## Appeal Decision

Decision date: 6 January 2017

**Appeal Ref: APP/R5510/D/16/3160629**  
**21 Parkfield Avenue, Uxbridge UB10 0DF**

01

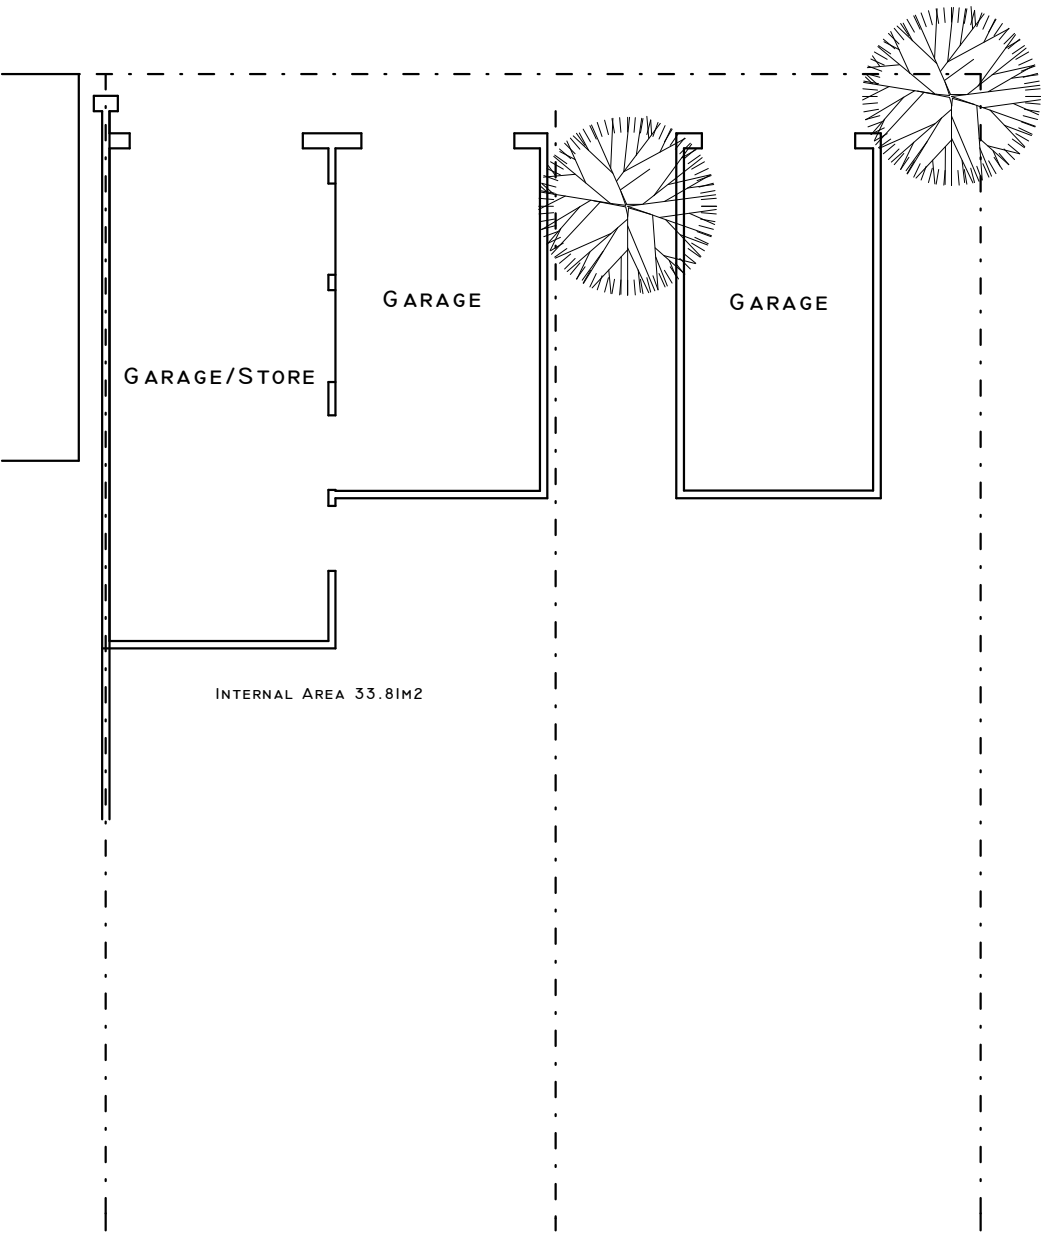
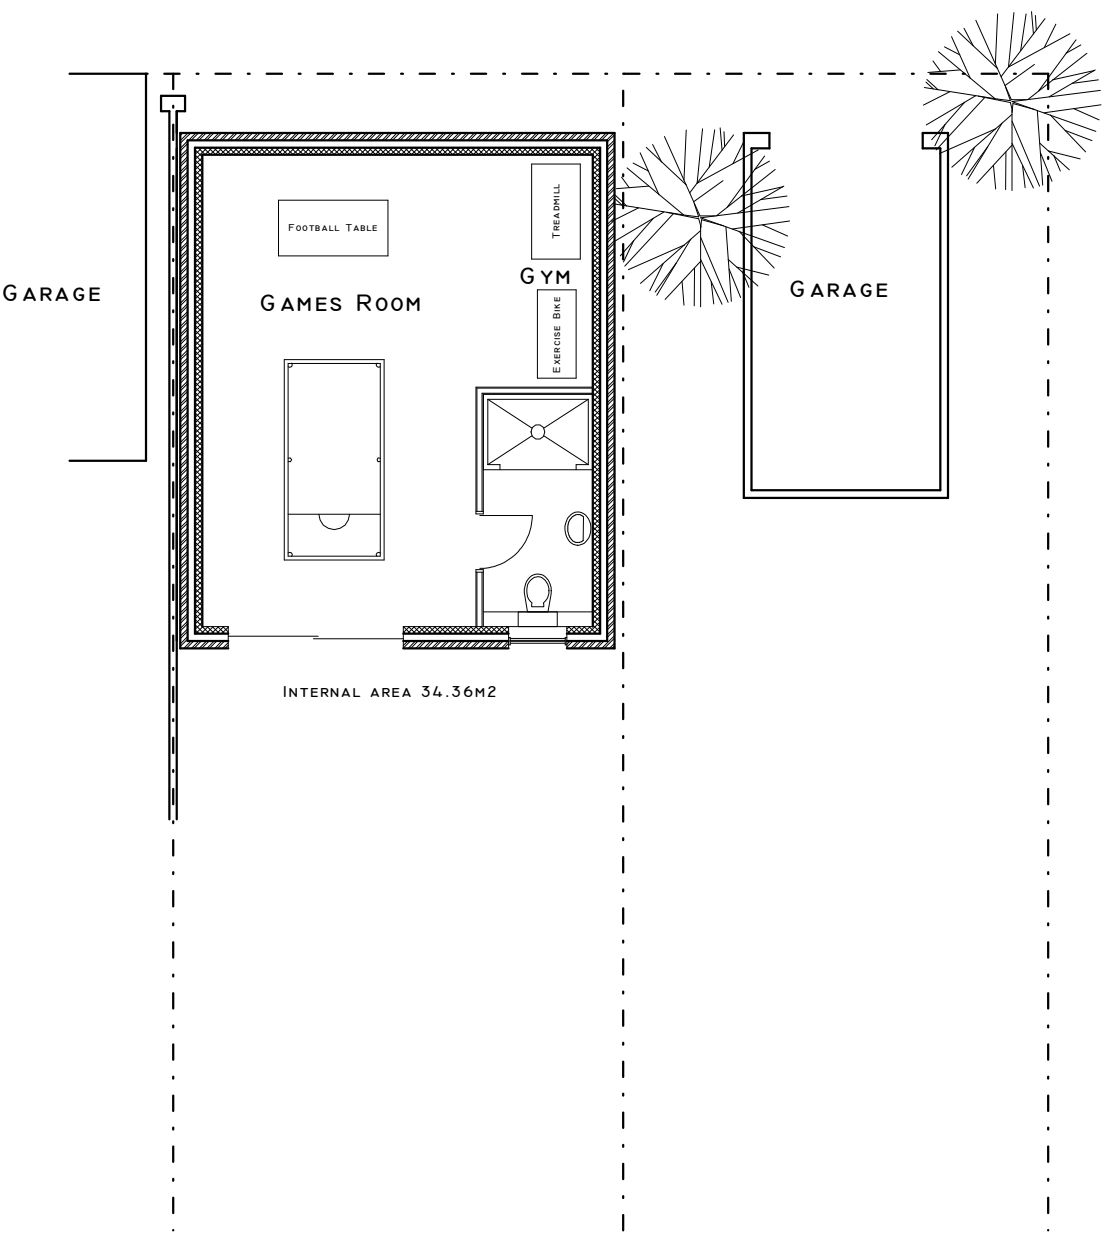
2. An amended plan, Drawing No 01 Rev A, has been submitted as part of the appeal and involves the removal of internal walls. I consider the changes proposed to be minor and the Council have had an opportunity to comment on the amended plan. I do not believe that any party would be unfairly prejudiced by my determining of the appeal with regard to the amended plan and I have done so on this basis.

6. The appellant considers that the proposal would not exceed the footprint of the original dwelling, and based on what I saw during my site visit, I agree. Moreover, I note that the proposal would be roughly only 5 square meters larger than the existing garages. The exercise equipment and gaming equipment illustrated in the proposed plan also demonstrates that the size of the outbuilding is not unreasonable for what is being proposed.

7. The outbuilding would be used as a games room, gym and would contain a shower room with toilet. I note that the outbuilding would not contain any bedrooms, a kitchen or a living room that would enable it to operate as an independent dwelling. Furthermore, the outbuilding would be located close to the main dwelling and would not contain any openings onto the rear lane. In any event, the lane is unlikely to provide a useable access for occupants of a dwelling. The outbuilding would share existing parking and access arrangements with the main terraced dwelling. Consequently, based on the evidence before me, the proposed outbuilding would not amount to an independent dwelling.
